From: Sue Howell
Sent: 26 February 2025 13:39
To: Planning.Responses; Jessica Riches
Subject: Planning Consultation on: F/14/24/RES, F/15/24/RES, F/16/24/RES

Response to Planning Application

From: Arun District Council Leisure & Greenspace

Location: Land at Ford Airfield Ford

Status:	Drawn by:	Checked by:
For Planning	GP	TF
Project Number:	Scale @ A1:	Date:
180641	As shown	06/2024
Drawing Number:		Revision:
TOR-RMIN-XX-DR-L-P-011

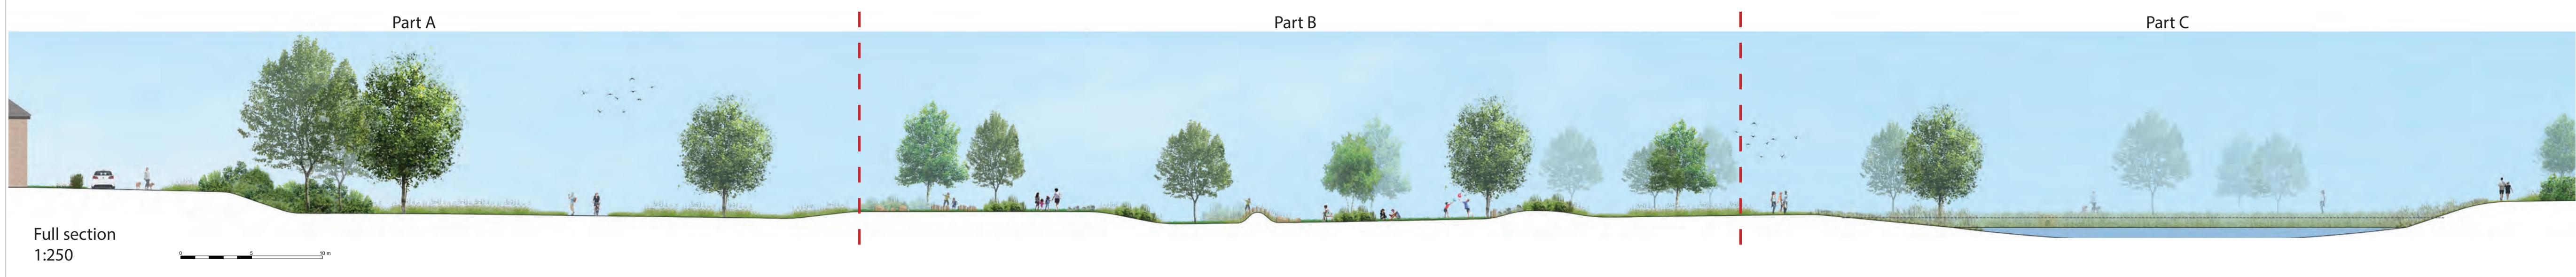
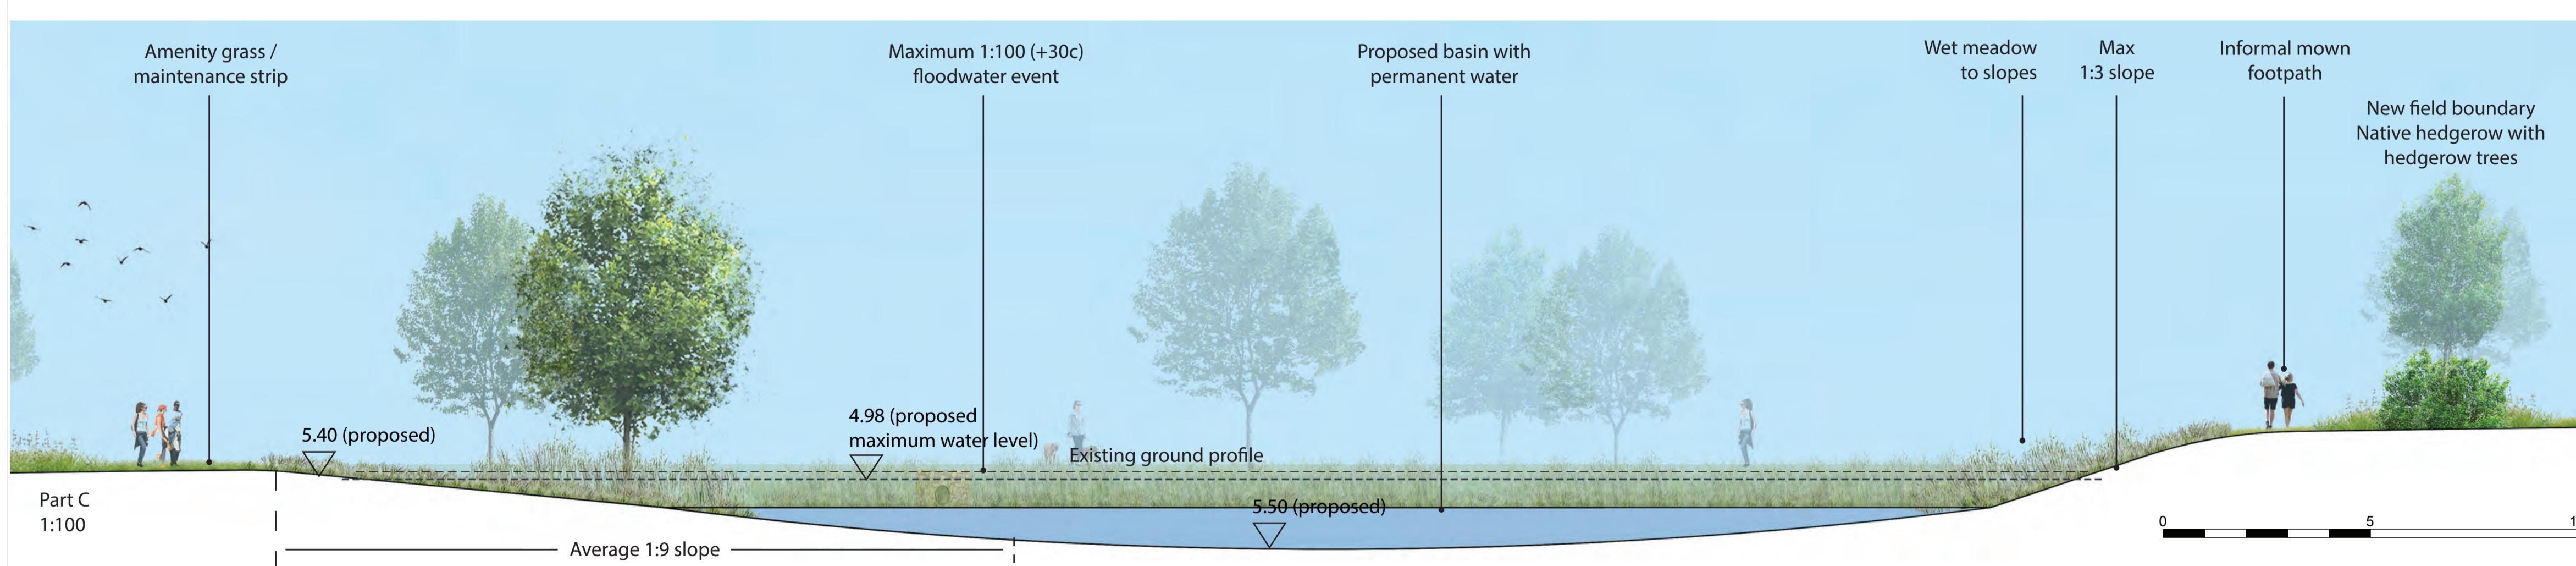
Previous query - Spine Road / Runway: Whilst the central main road runs through the entire of the site, roundabouts excluded from the plans. This is particularly important along the Ford Lane frontage, where much time has been spent in order to ensure that the simple character of the lane is preserved, and the roundabout could potentially have a large impact upon this.

As in the case of the canal, the spine road cuts through the line of the runway. This road and verge feature will interrupt the line, flow and visibility of the runway, and the proposed new area of open space which has been designed to reflect the shape dimensions and open character of this heritage asset. Essentially, rather than having one larger space, it will look and feel like two smaller linear parks. This is not positive and harms the impact that has been created through the retention of the runway. Ideally, the landscaping in this section of the road corridor should be informed by the runway. The result should be one long continuous green corridor along the route of the runway.

The runway / spine road crossing has been reviewed and now indicates the central footpath prioritised across the spine road in accordance with the Design Code. The section of road is on a raised table to aid in traffic calming crossing the runway and indicated by change of surface to block paving. Tree planting has been sensitively positioned to align to the runway corridor and are of medium species size to ensure strong visual links and open character are maintained running through the runway corridor. **Request** confirmation of what is meant by medium species size ie is this ultimate growth spec or size at time of planting?
